Consultation Response from KC, Highways Development Management (HDM)

2023/91212 Land off Bankfield Drive, Holmebridge, Holmfirth, HD9 2PH

Erection of 16 dwellings with access from Laithe Avenue

Date Responded: 19/06/23 | **Responding Officer:** A.Darwin | **Responding Ref:** HDC 3-26/3

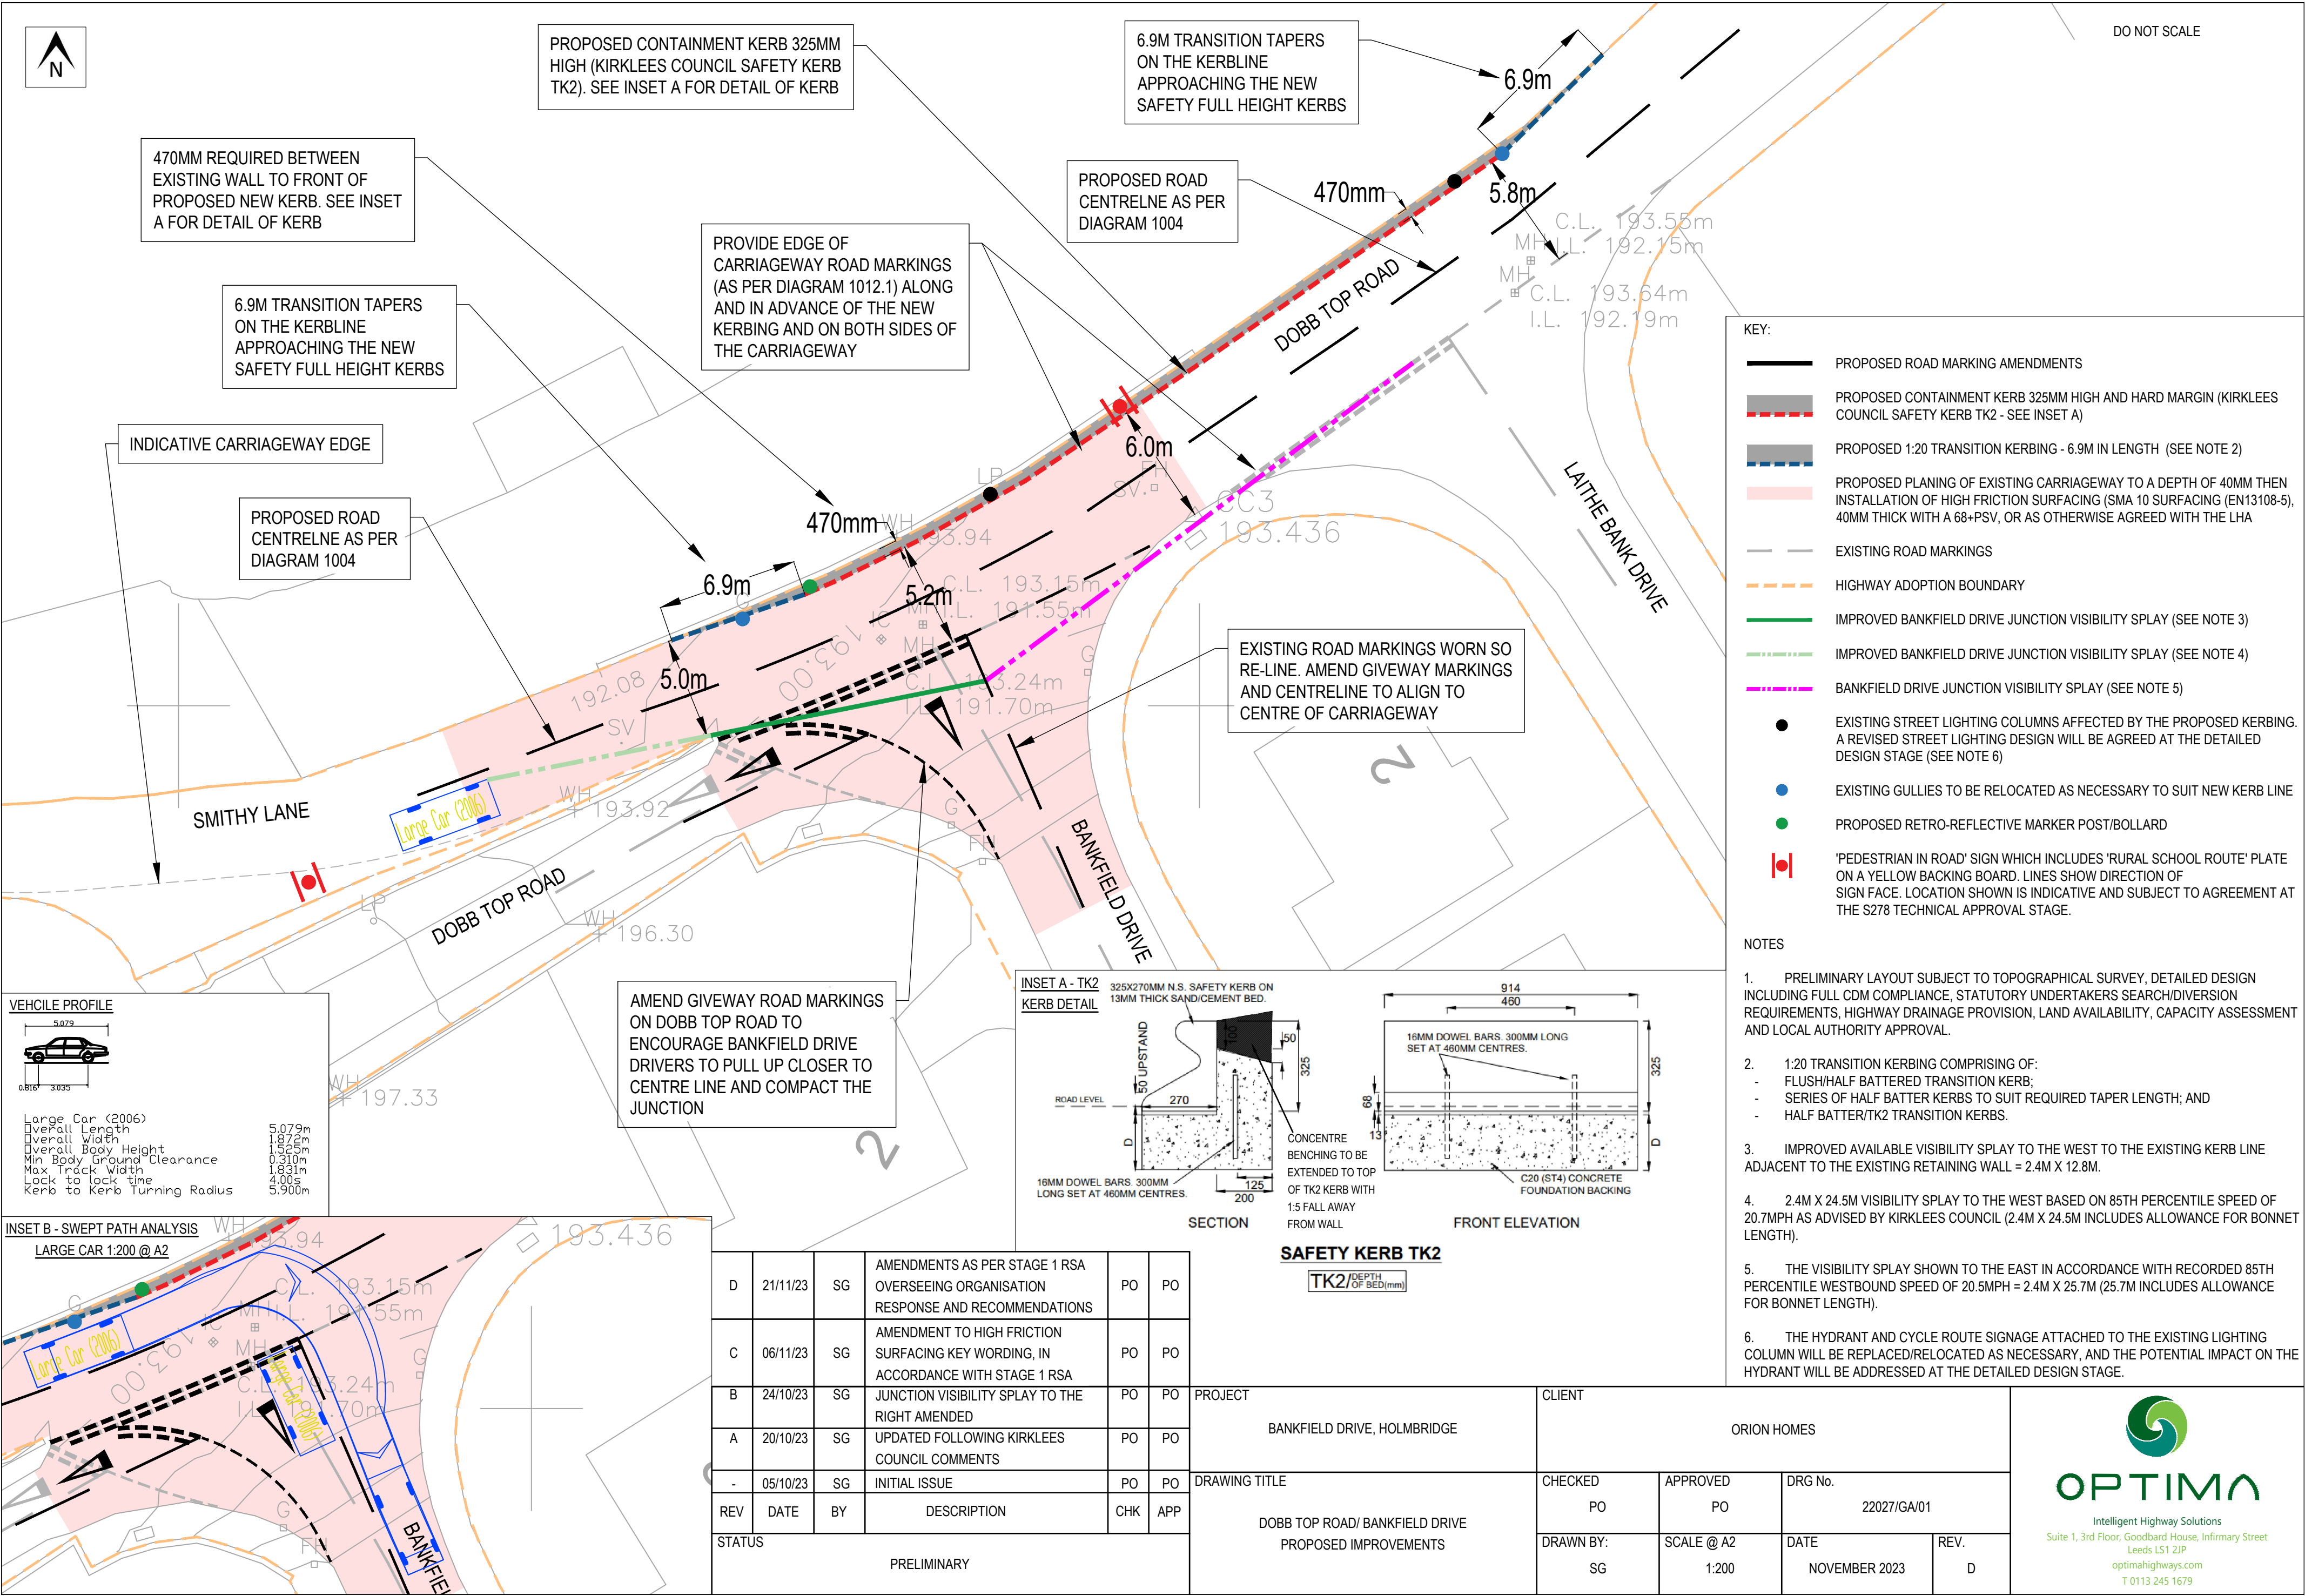
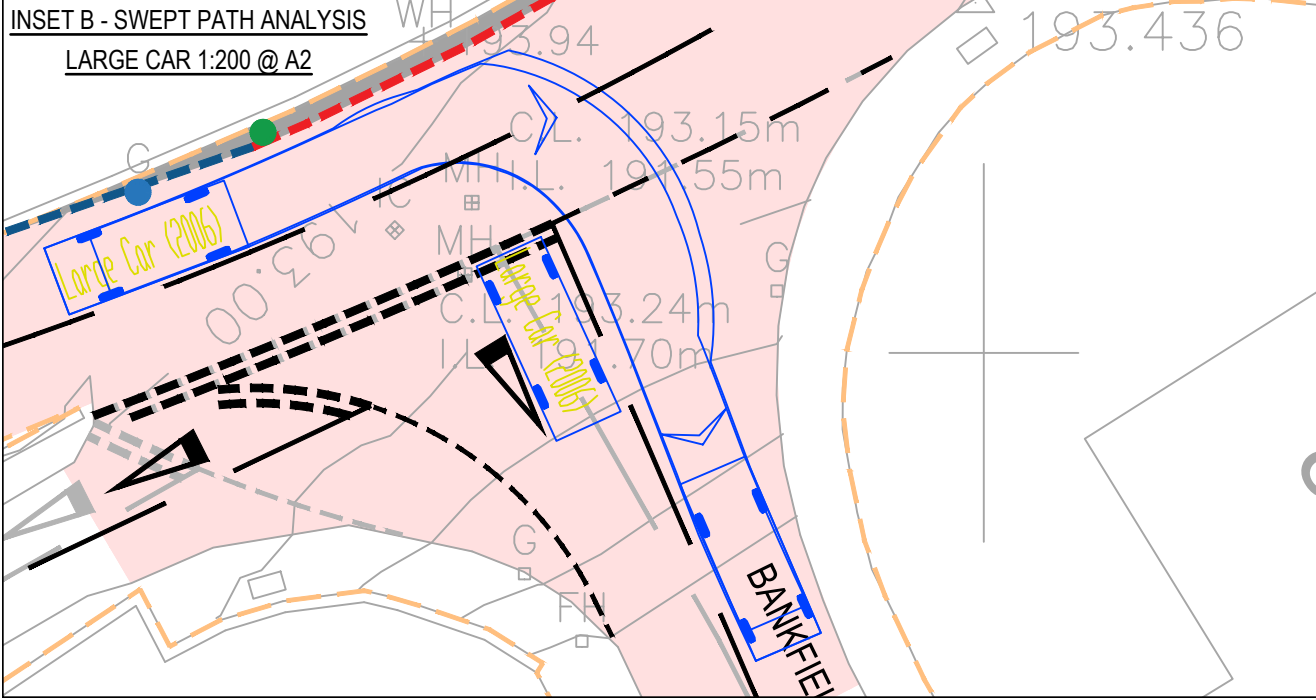
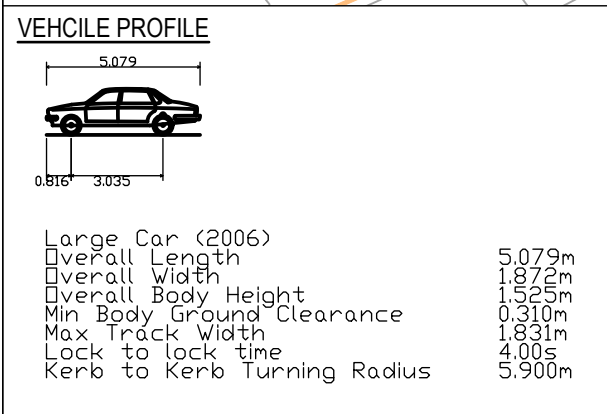
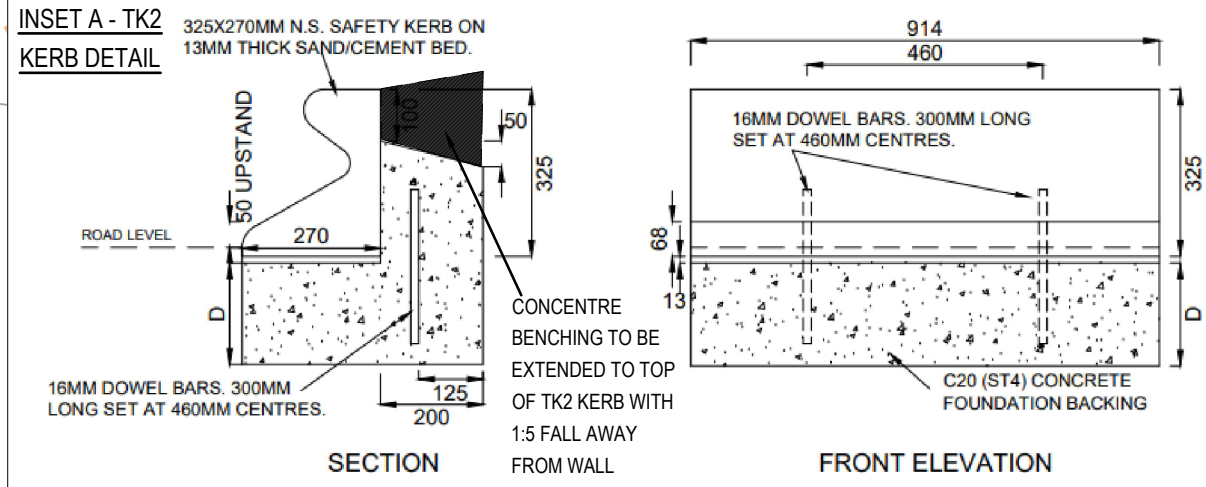
- Notwithstanding the above, assuming speeds are 20mph as has been suggested, this would require visibility splays of 2.4x25m. Whilst the Transport Statement has not clarified the available visibility at the junction, the above splays are clearly not achieved, with HDM estimating that the splay to the west is circa 2.4x16m at best. Therefore, the visibility splay is sub-standard and improvements are required.

In light of the above, HDM reiterate that improvements to junction visibility are required at this junction.

JOB No	DRG No	REV
21043	101	F

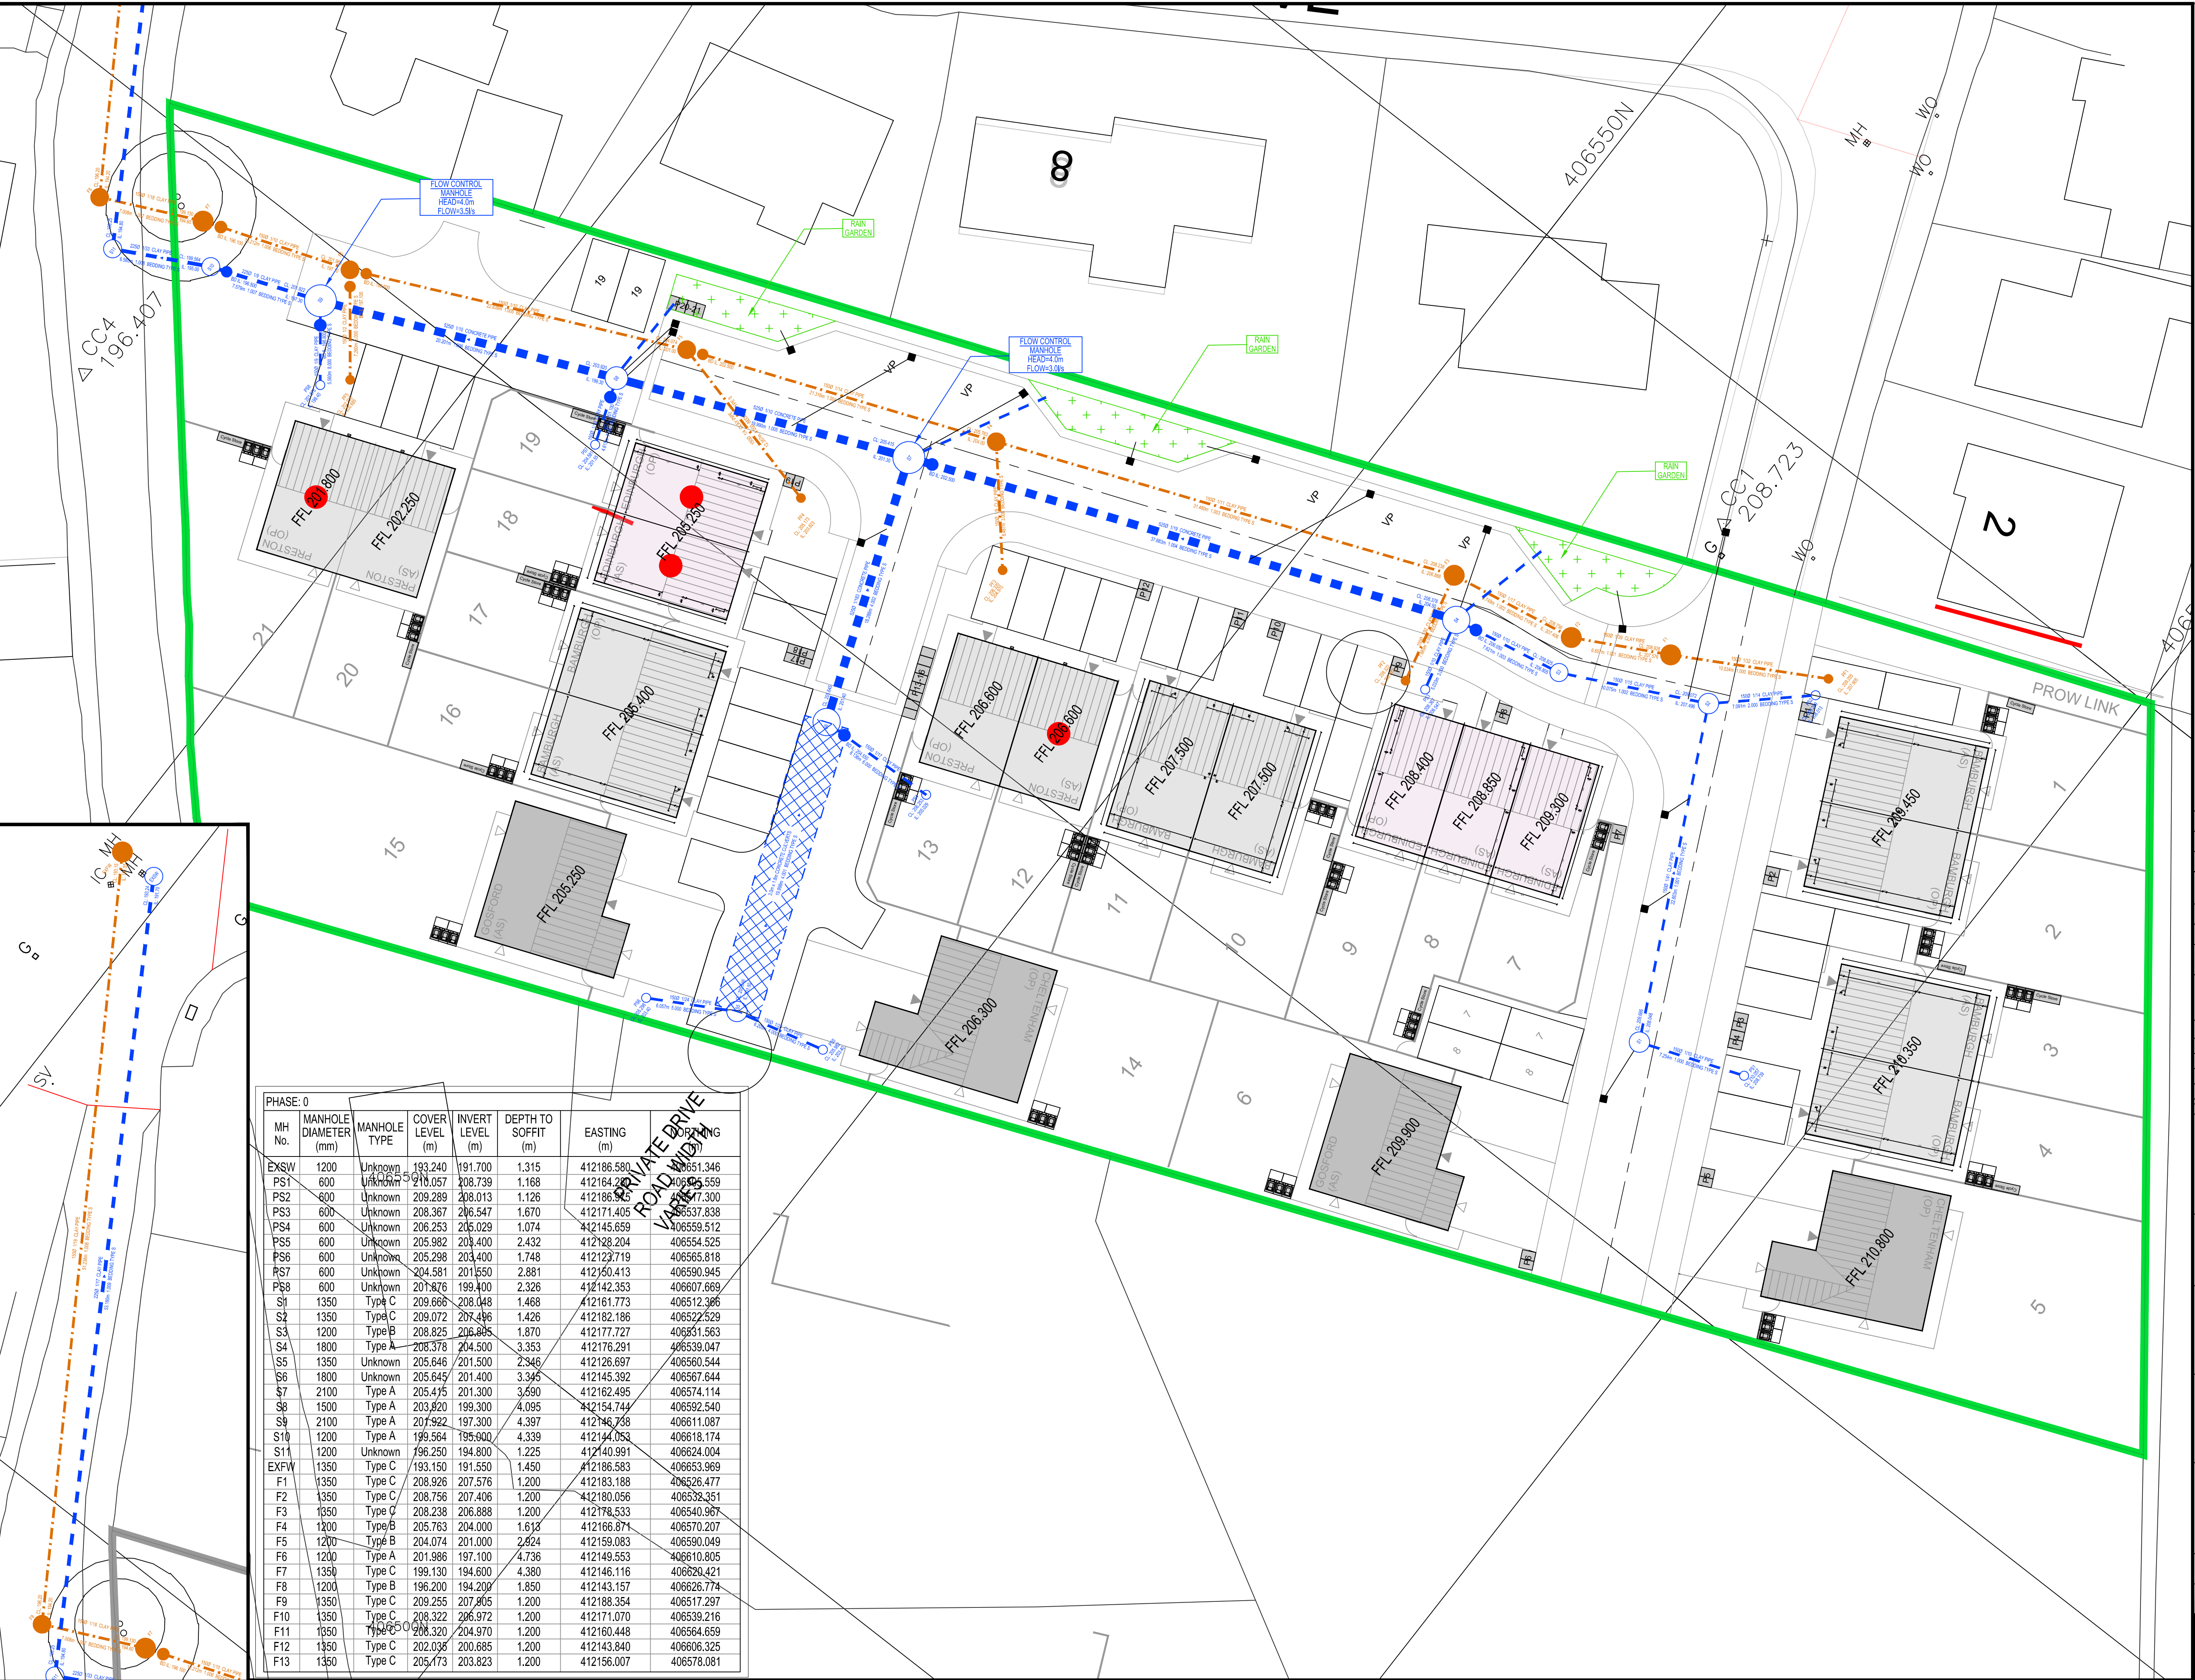
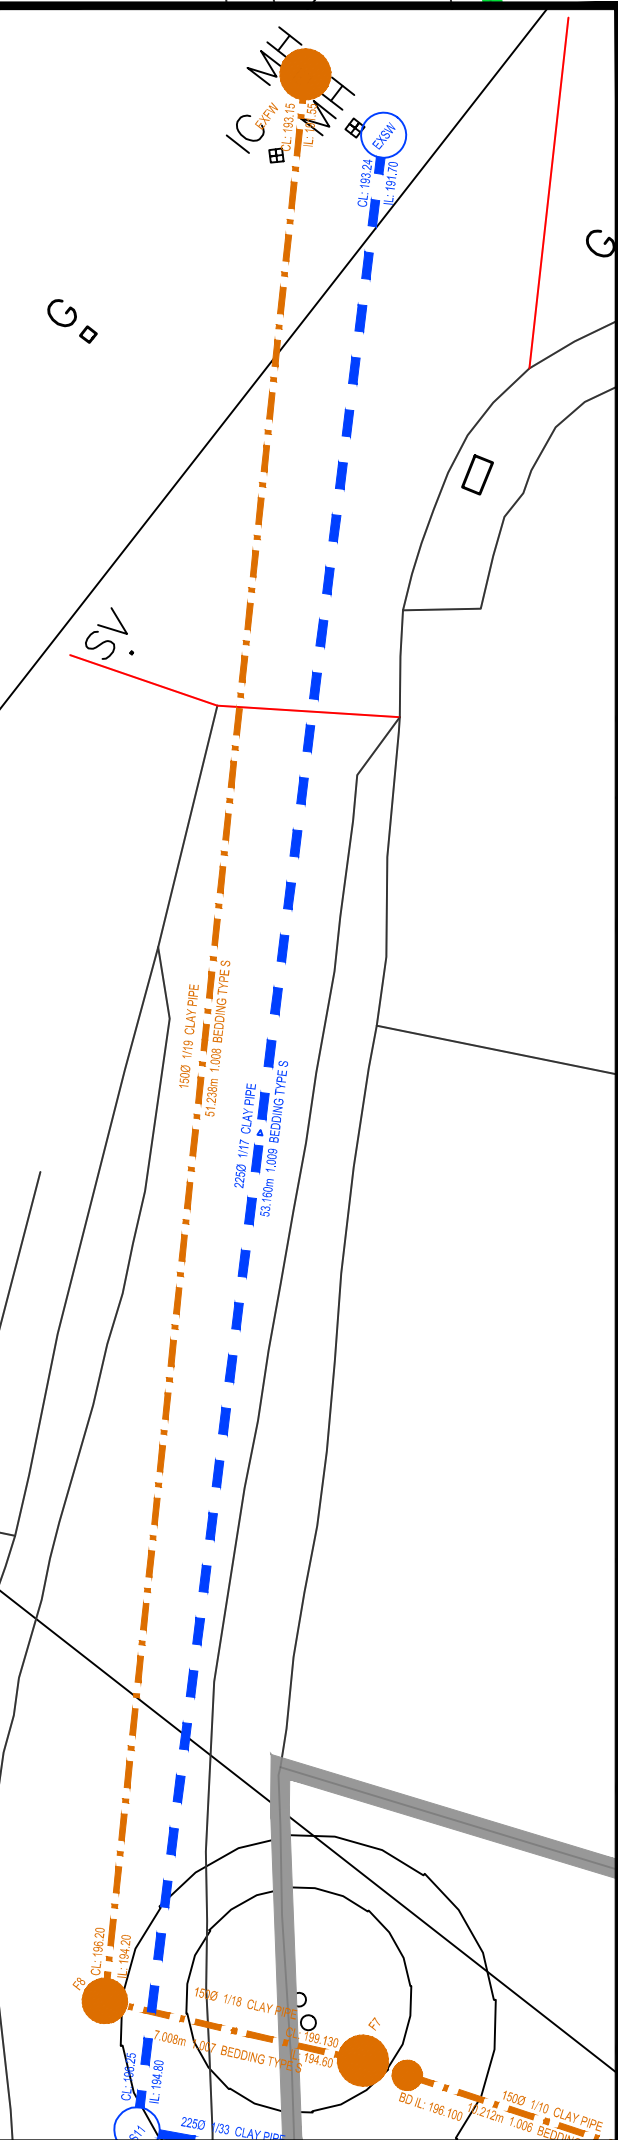
- The extent of the proposed adopted highway has not been indicated on the plans. Therefore, this must be confirmed on the submission drawings, with all junction and forward visibility requirements incorporated into the adopted highway. The extent of shared private drives should also be identified, as well as confirmation of how future maintenance will be secured.
- A turning head for light vans is proposed for the private drive serving plots 13 & 14, which is welcomed. However, the turning head is located in close proximity to the existing retaining wall fronting Dobb Top Road. Therefore, confirmation is required that the existing retaining wall can take this vehicle loading, and what if any works are proposed to this retaining wall (it is assumed it will be partially reconstructed, to allow the new site drainage to be installed?).
